**KIRKLEES METROPOLITAN COUNCIL
INVESTMENT & REGENERATION SERVICE**

DELEGATED DECISION TO DETERMINE PLANNING APPLICATIONS

Reference No:	2025/62/90006/W
Site Address:	106, Taylor Hill Road, Taylor Hill, Huddersfield, HD4 6HJ
Description:	Erection of first floor extension and associated alterations
Recommending Officer:	Joshua Merriman

HOUSEHOLDER DELEGATED REPORT

scale	date	sheet size	dwg. no.
1:100	11/2024	A3	24/1094/07a

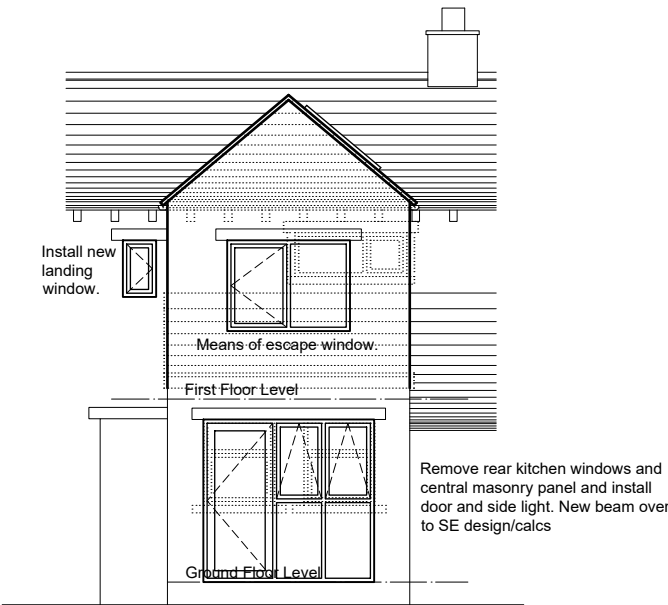
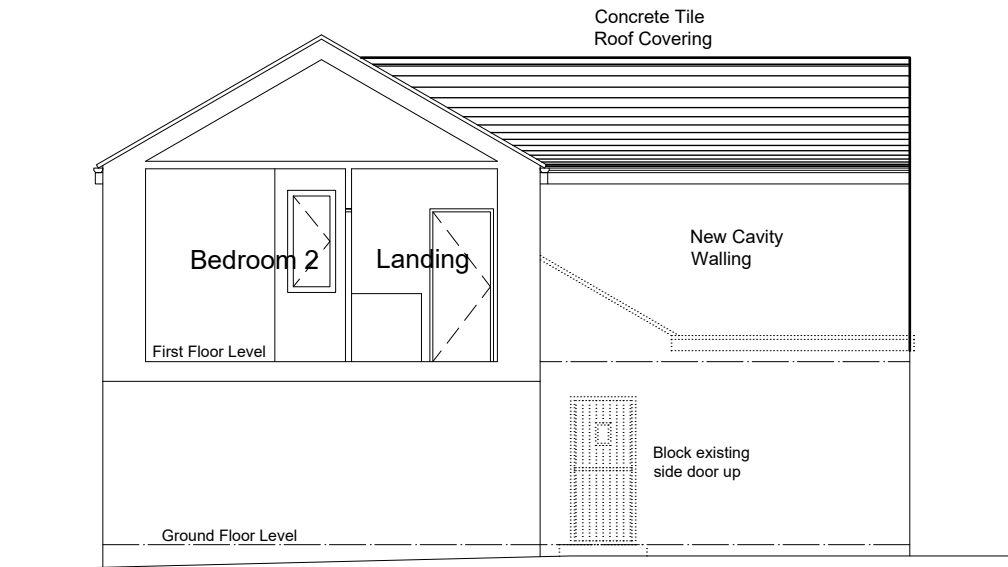
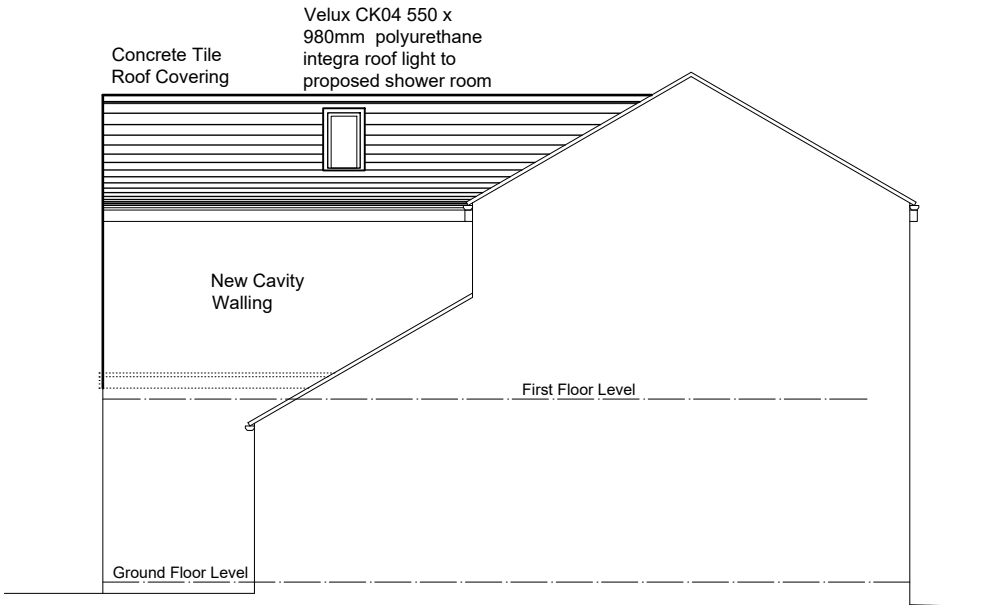
The proposed rear extension will project 4.89m from the rear elevation of the existing building (the same distance as the existing ground floor rear extension), with a maximum height of 6.44m, eaves height of 4.77m, and a width of 3.26m.

it is considered that this can be accepted in this case.
not exceed a height at the eaves of 3 metres where the extension is within 1.5 metres of the property boundary		The extension is set to have an eaves height of 4.77m within 1.5m of the property boundary, however, as aforementioned, due to this having no significant impact on neighbouring dwellings, it can be considered acceptable.
be separated from the property boundary, such as a wall, fence or hedge, by at least 1.5 metre		The property is not separated from the property boundaries by 1.5m currently due to the close proximity of the terraced dwellings, therefore, as this is currently the case for many properties on Taylor Hill Road, it is considered acceptable.
not adversely affect habitable room windows where they adjoin a neighbour's boundary	There will be no significant impacts on habitable room windows in neighbouring properties, as those windows to the rear of neighbouring dwellings service bedrooms and kitchens.

scale	date	sheet size	dwg. no.
1:100	11/2024	A3	24/1094/06b

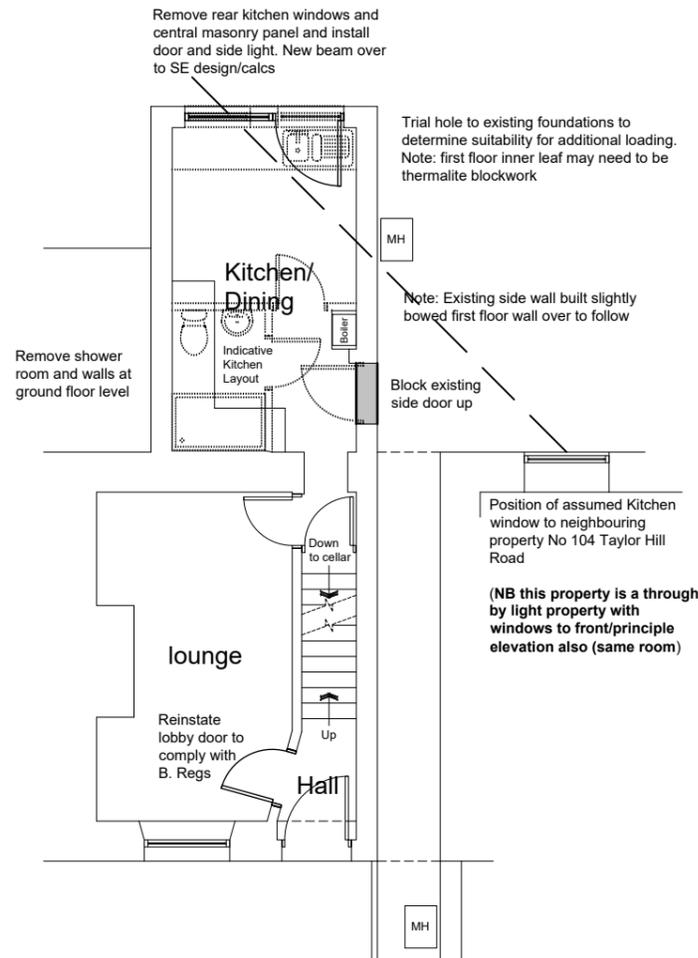
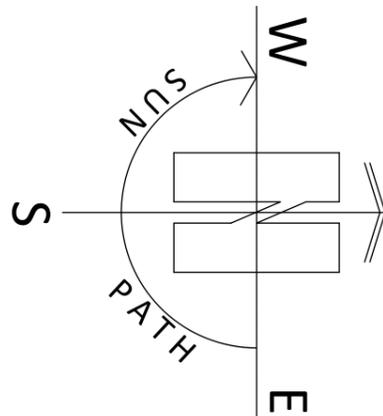
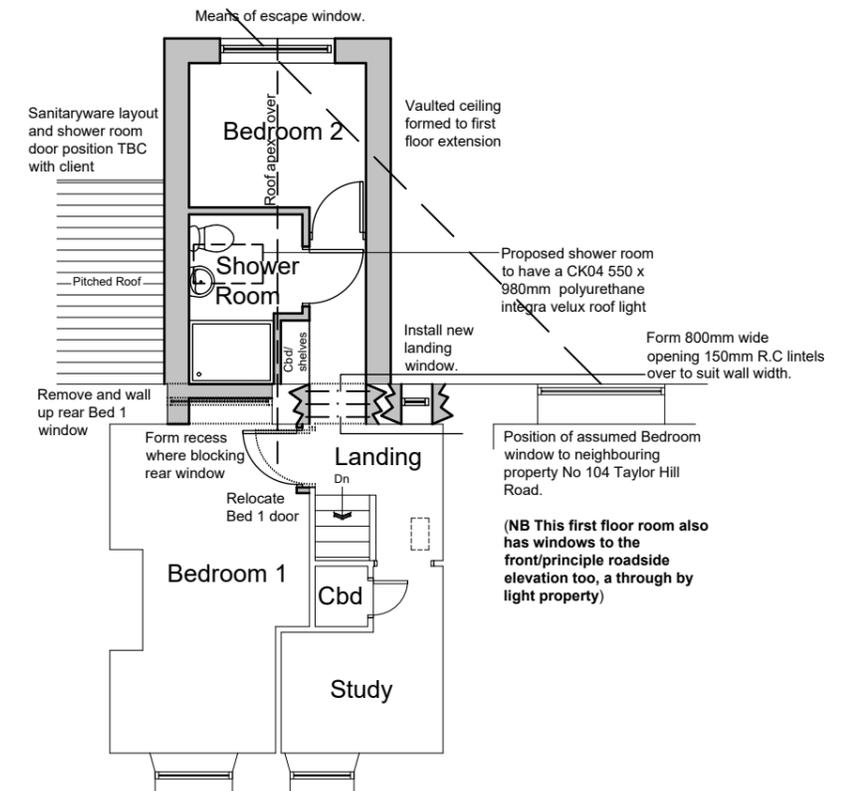
YES / NO	SUMMARY
Negotiations/Amendments during course of application	Yes	Negotiations have been ongoing throughout the course of the application including the case officer requesting a 45-degree angle from the centre sill of the closest neighbouring windows being added to the submitted plans. Moreover, the rooms serviced by the closest neighbouring rooms were requested by the officer. Finally, it was explored if the extension could potentially be moved away from 104 Taylor Hill Road to lessen any impacts on residential amenity, however, this was not considered feasible likely due to the impact on internal layout. For the reasons set out below, the original plans have been concluded as acceptable, as any new impacts by reason of the development will not be so significant that they would be

Pursuant to article 35 (2) of the Town and Country Planning (Development Management Procedure) Order 2015 and guidance in the National Planning Policy Framework, the Local Authority have, where possible, made a pre-application advice service available, complied with the Kirklees Development Management Charter 2024 and otherwise actively engaged with the applicant in dealing with the application. The case officer sought it necessary to seek amended plans including the 45-degree angle from the centre sill of the closest neighbouring windows.
